Project Name: **Parking Lot Expansion**
Project ID: 2013-056
Address: 741 Warren Avenue CBL: 316-A-500B
Applicant: Downeast Veterinary Emergency Clinic
Planner: Jean Fraser

On September 18th, 2013, the Planning Authority approved with conditions a Level II site plan for Parking Lot Expansion comprising 35 parking spaces and associated drainage and landscaping at the rear of 741 Warren Avenue. The decision is based upon the application, documents and plans as submitted by Downeast Veterinary Emergency Clinic and prepared by Sebago Technics.

The approved Plans comprise: Sheet 1(Overall Site Plan) Rev D (9.3.2013); Sheet 2 (Site Plan) Rev D (9.12.2013); Sheet 3 (Grading and Utility Plan) Rev E (9.6.2013); Sheet 4 (Erosion Control Notes & Details) Rev B (6.13.2013); Sheet 5 (Site Details) Rev B (6.13.2013); and Sheet 6 (Drainage Plan) Rev B (6.13.2013).

TO: Jean Fraser, Planner
FROM: David Senus, P.E.
DATE: August 16, 2013
RE: 741 Warren Avenue Parking Lot Expansion, Level II Site Plan Application

**UNDERDRAIN SOIL FILTER SECTION**

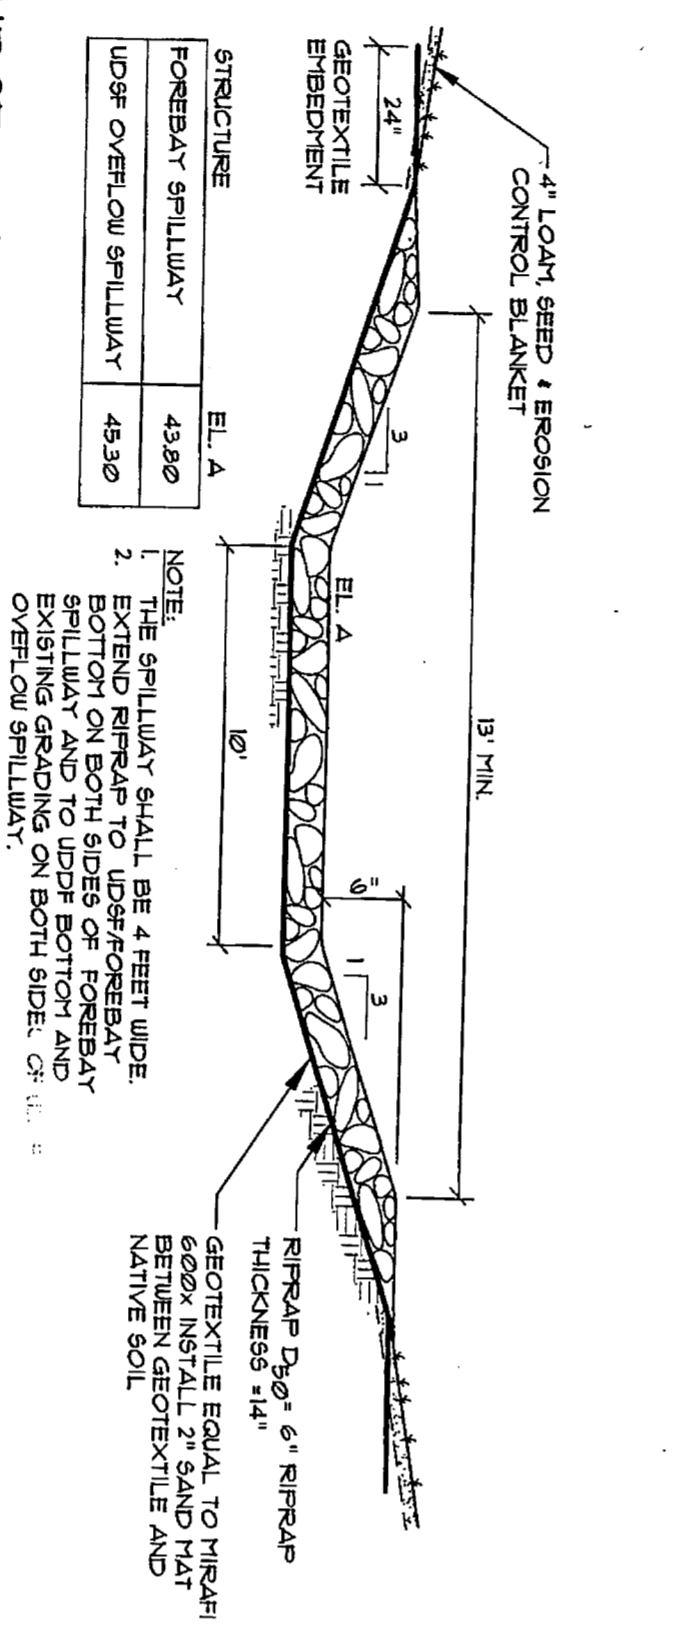
- 1) The Underdrained Soil Filter Inspection, Maintenance and Housekeeping Plan does not identify the annual reporting requirements listed in Chapter 32 of the City of Portland Code of Ordinances. In addition, the plan should include an inspection and maintenance checklist for an underdrained soil filter system to catalogue completed tasks.
- 2) All other comments have been adequately addressed.

- 2) The Stormwater Management Plan should include a post-development stormwater inspection and maintenance plan developed in accordance with and in reference to MaineDEP Chapter 500 guidelines and Chapter 32 of the City of Portland Code of Ordinances.

**POST-DEVELOPMENT DRAINAGE PLAN**  
SCALE: 1"=20'

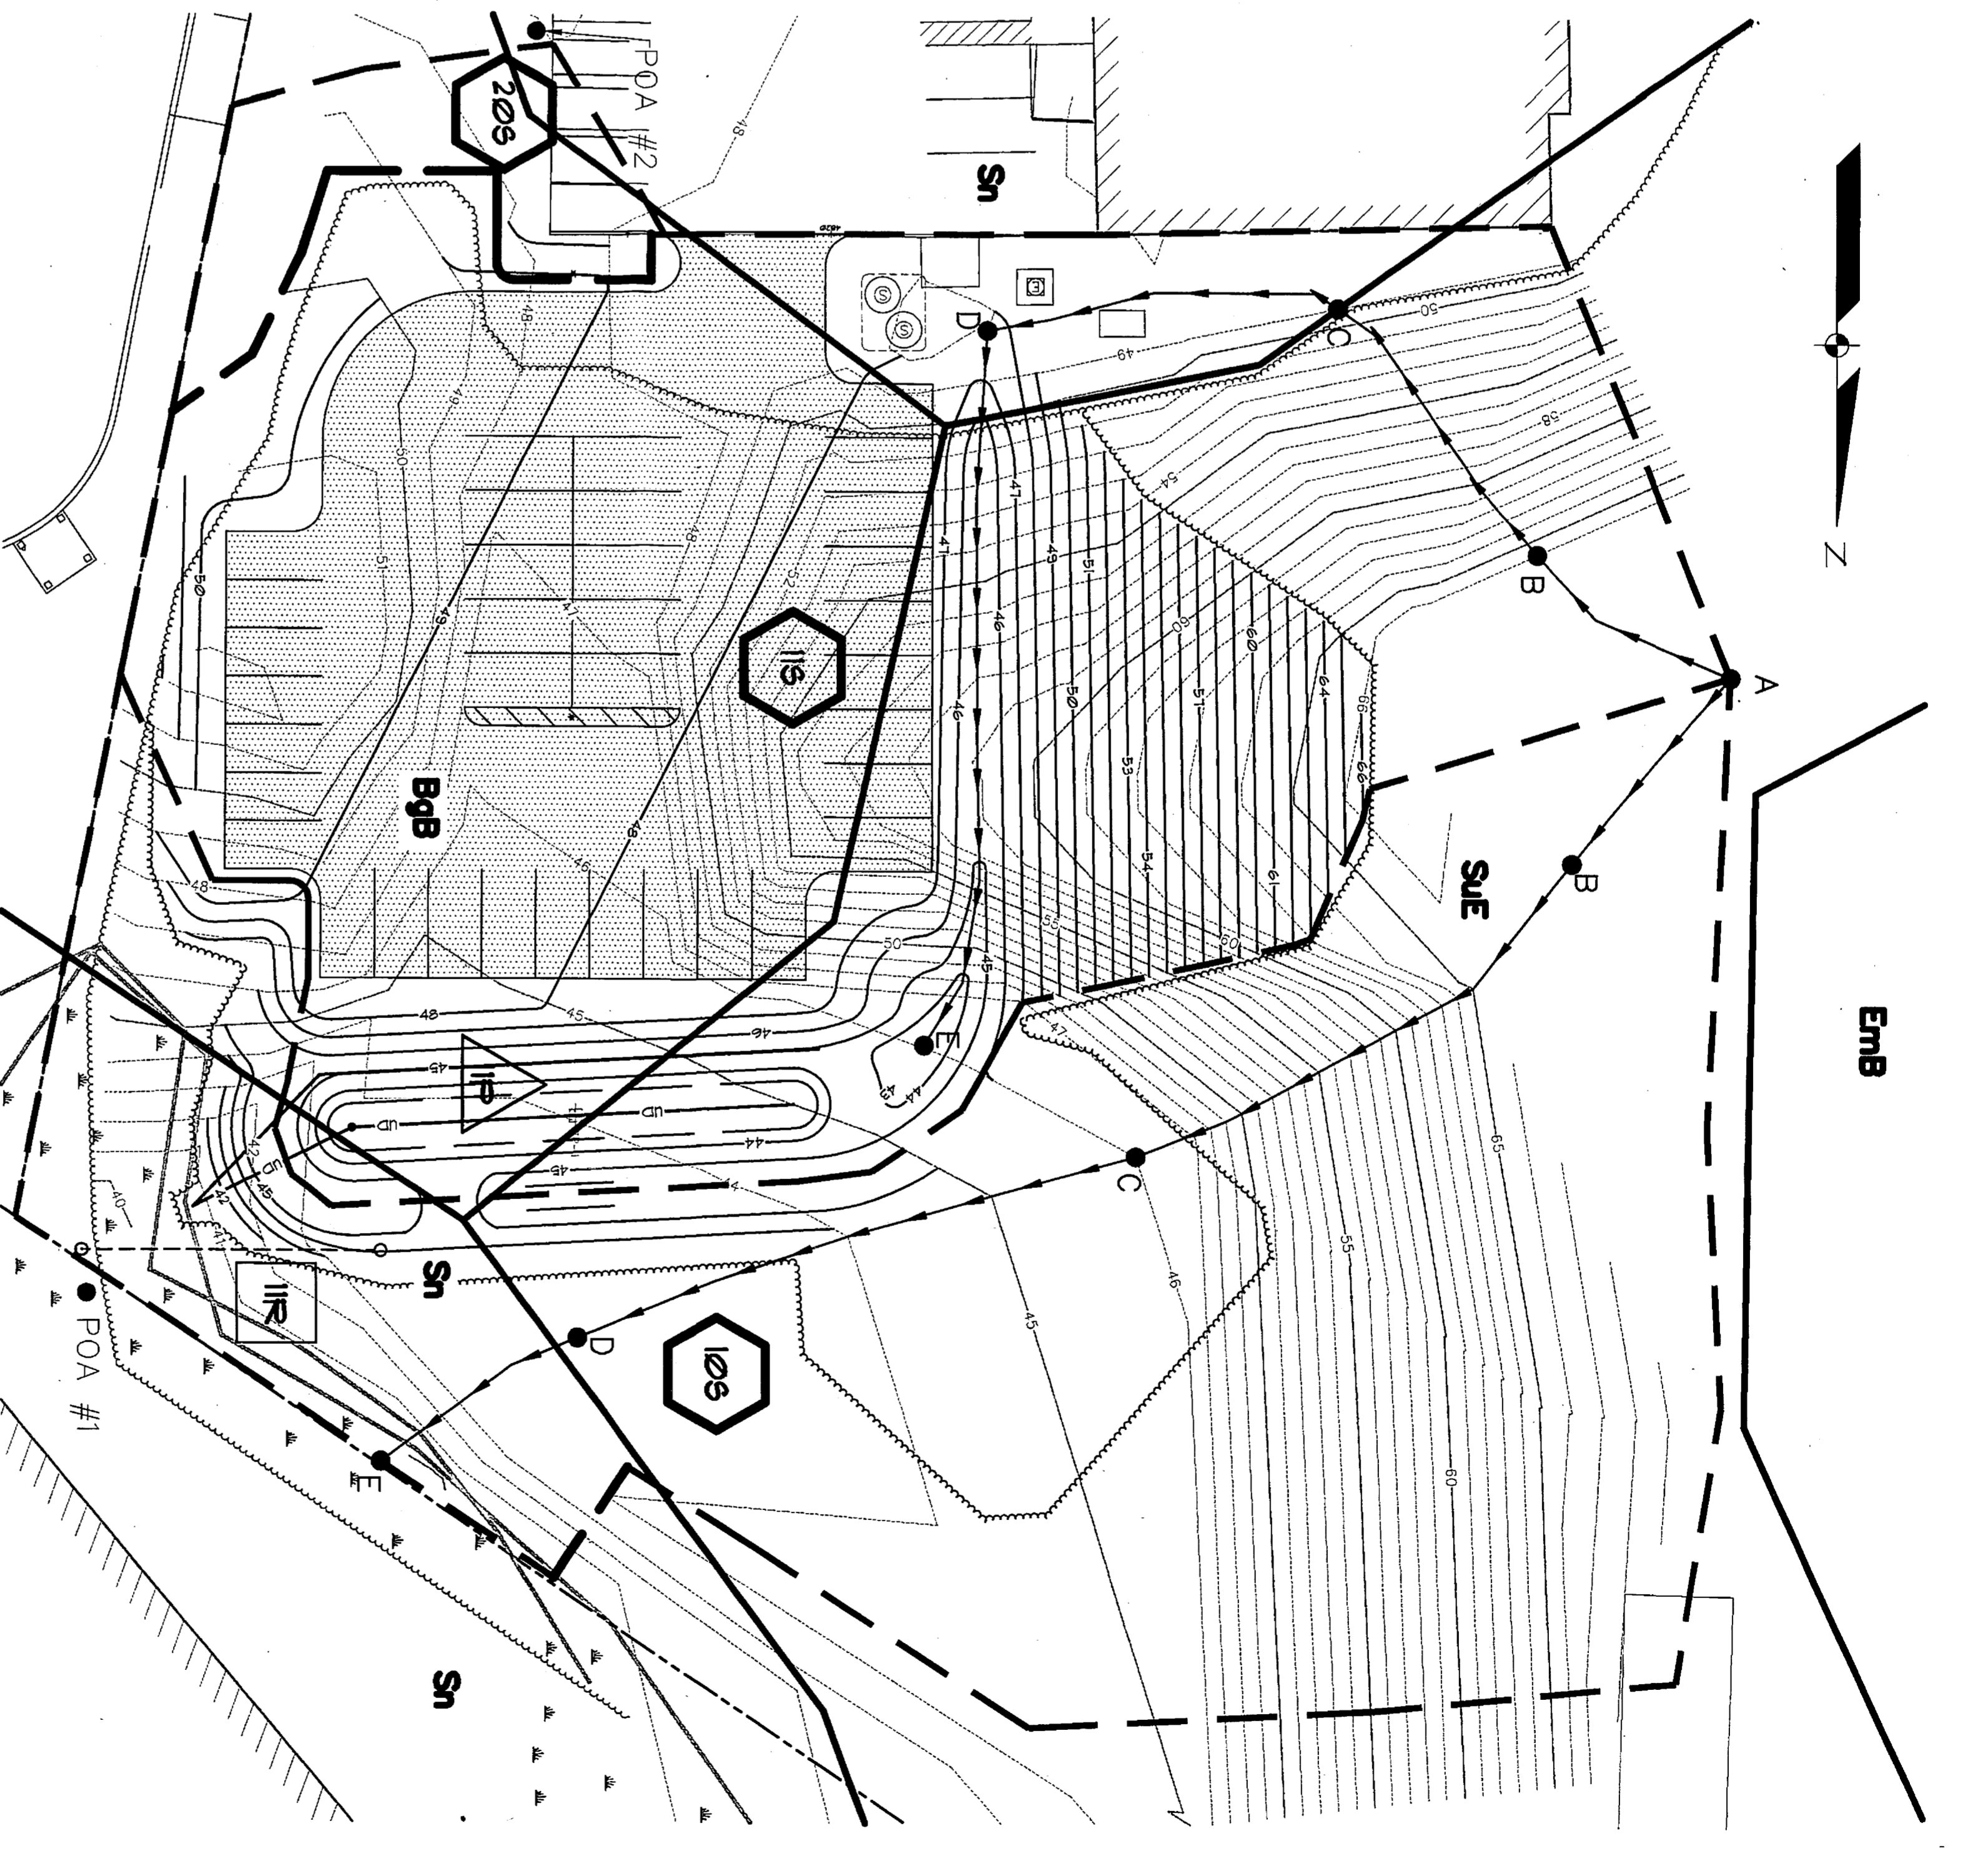
- > Identify specific means of preventing runoff from the new "fill area" from contributing sediment to the proposed underdrained soil filter or sediment forebay (during construction)
- > Include a post-development stormwater inspection and maintenance plan developed in accordance with and in reference to MaineDEP Chapter 500 guidelines and Chapter 32 of the City of Portland Code of Ordinances
- > Include a Riprap Outlet Protection detail for the proposed soil filter / underdrain outfall

The latest plans do not include new notes for the "fill area" to prevent sediment from entering the soil filter; I did not see a copy of the post development stormwater inspection and maintenance plan that they reference in their letter; and I could not find the riprap outlet protection detail that they note in their letter.
